## **SLAE Written Representation Submission for Deadline 9 - Construction**

This Written Representation reviews and comments on the five Construction titled documents.

### **TR020001-002894-5.02 Environmental Statement Appendix 4.1 Construction Method Statement and Programme Report**

### Inset 6.3: Assessment Phase 2b Earthworks (proposed areas of fill)

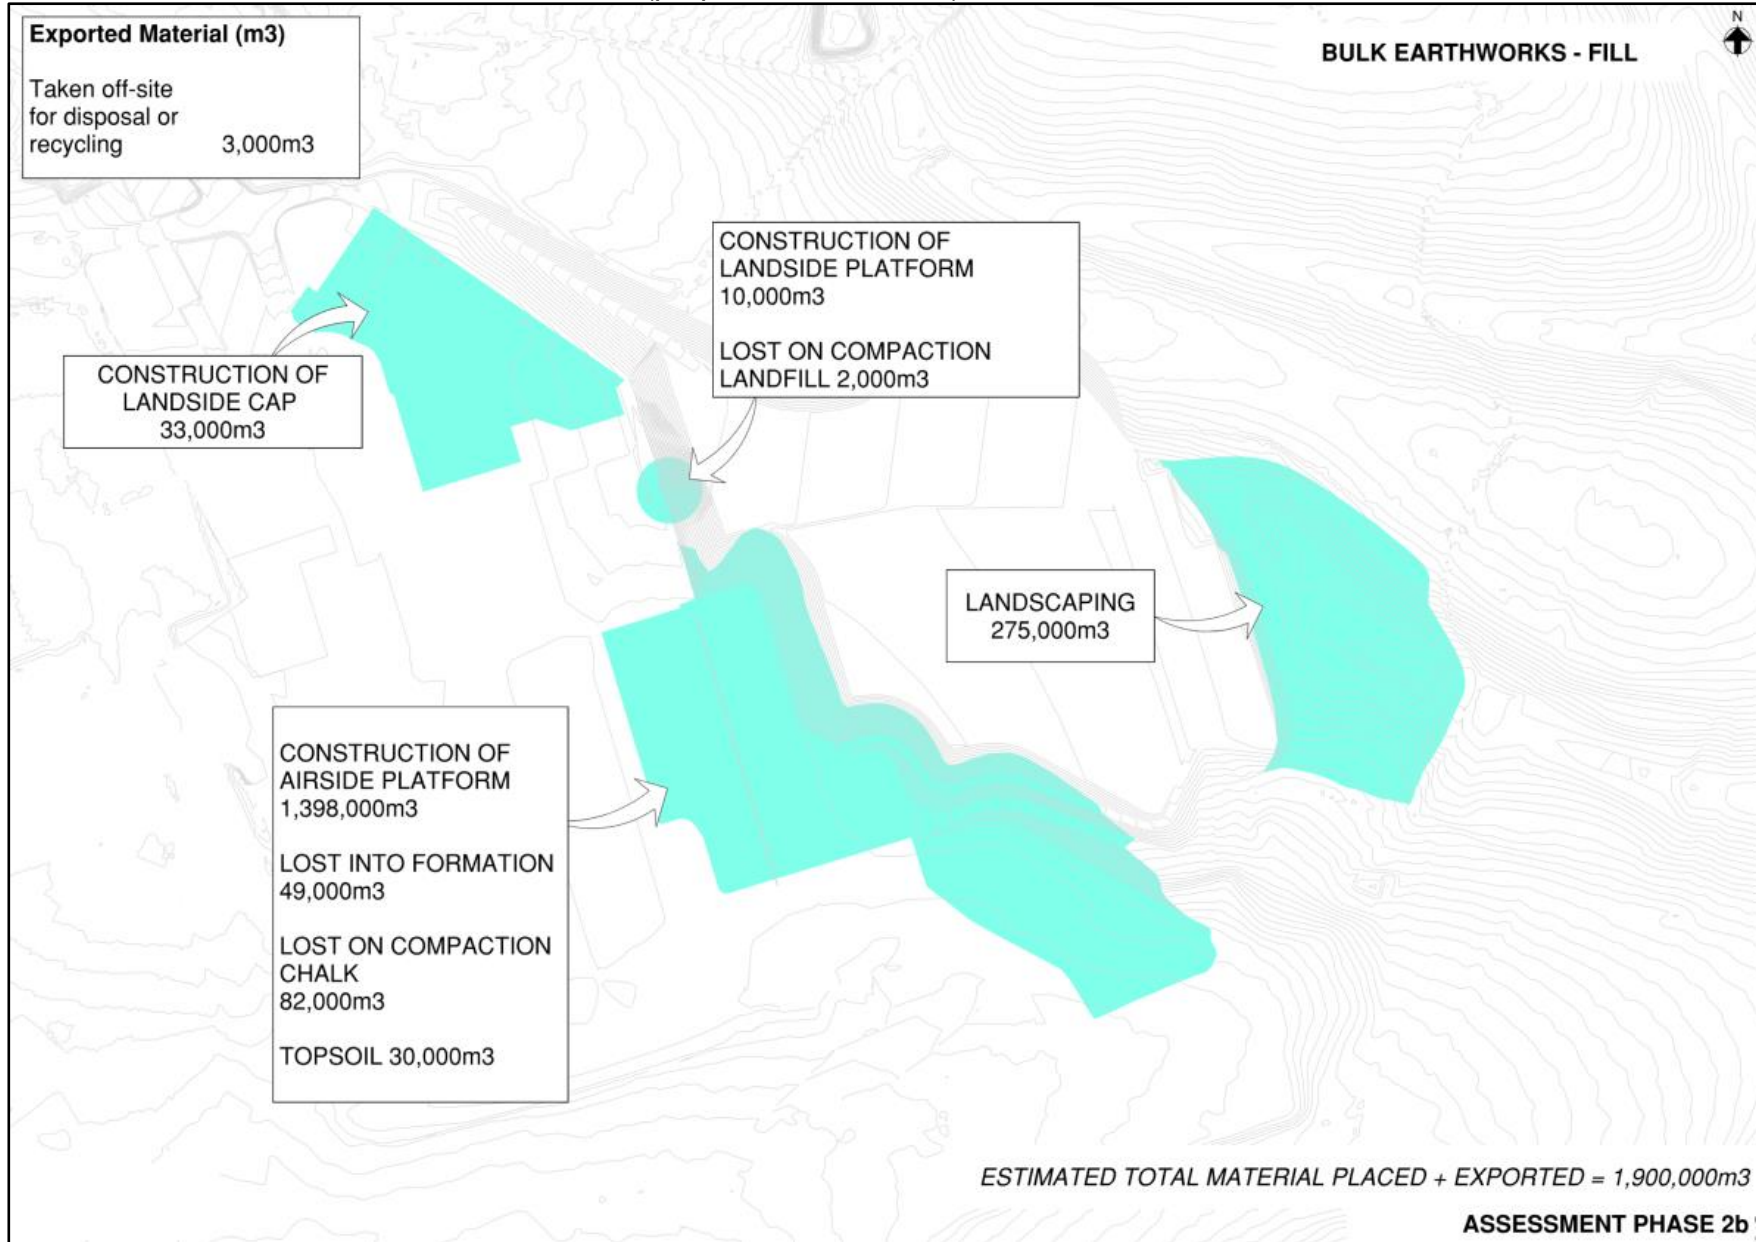
This also applies to those other diagrams shown in this document such as, Inset 5.3: Assessment Phase 2a Earthworks (proposed areas of cut), 5.3.27 The inset below shows areas of existing ground that excavated material would be deposited, 6.2. and 6.3.

Inset 6.6: Assessment Phase 2b Car Park Locations

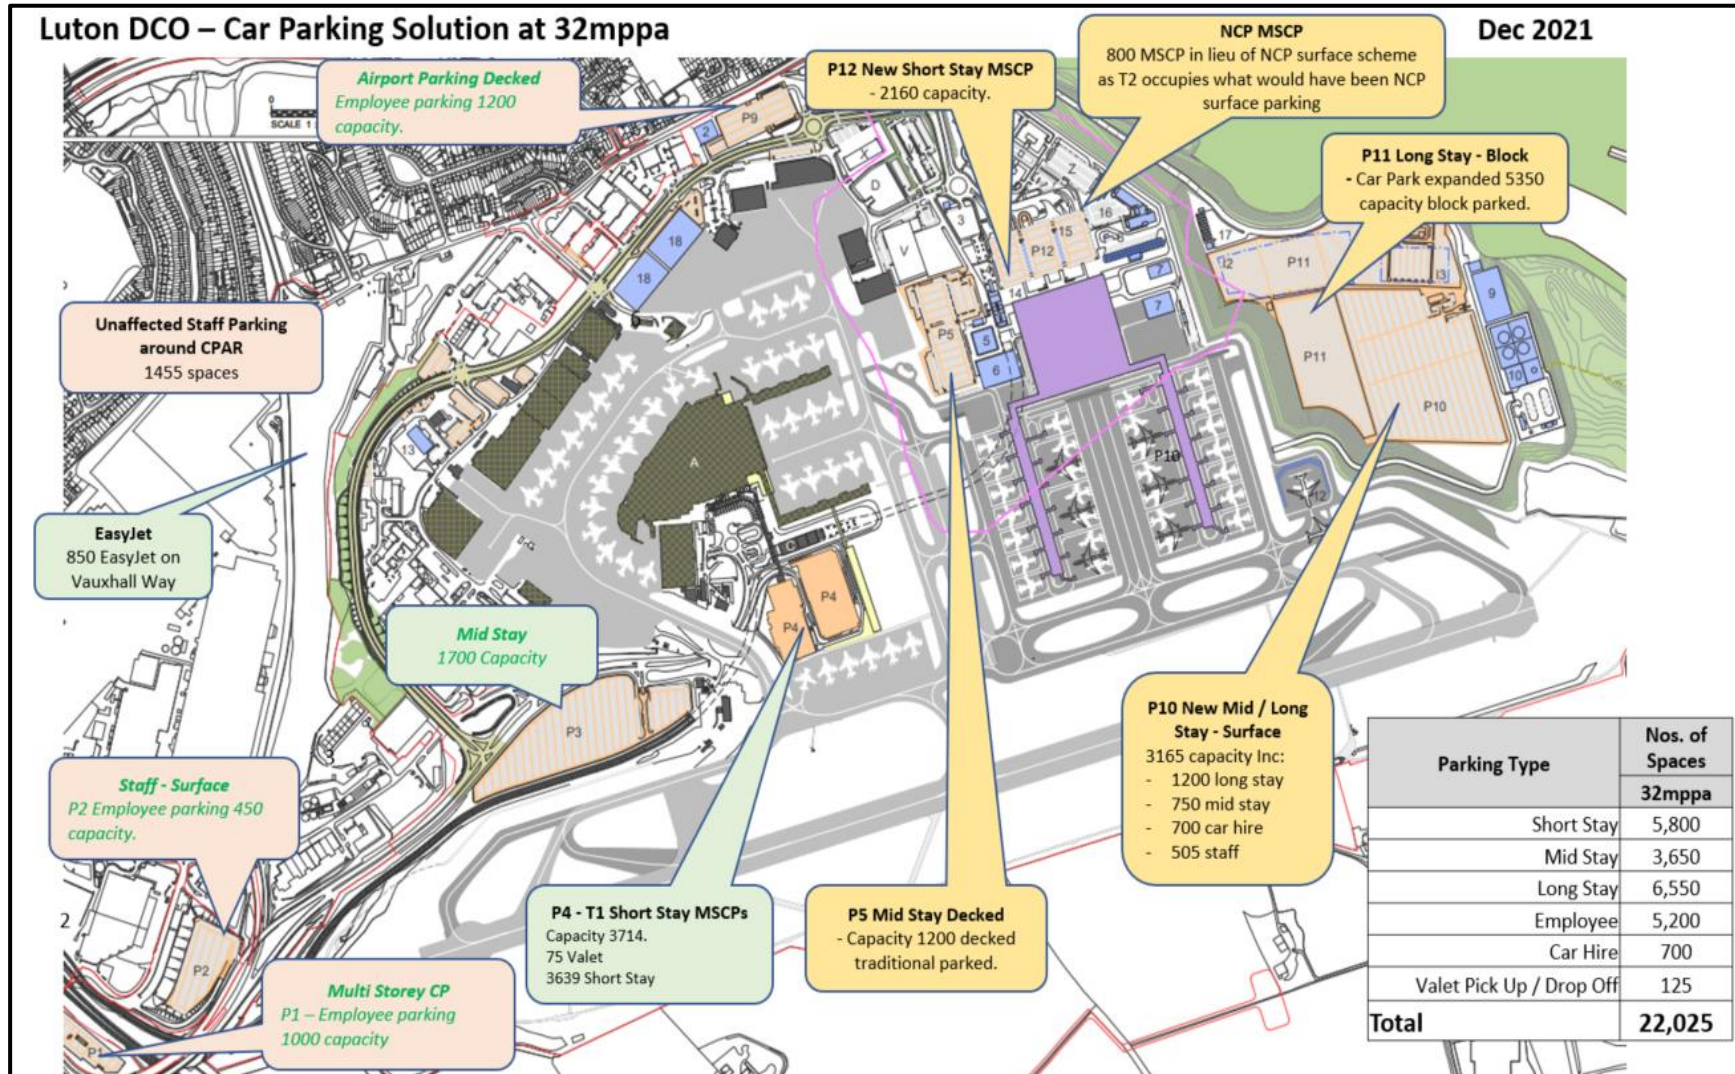
How can LR justify the destruction of the current Wigmore Valley Park and the County Wildlife Site for the building of so many car parks?
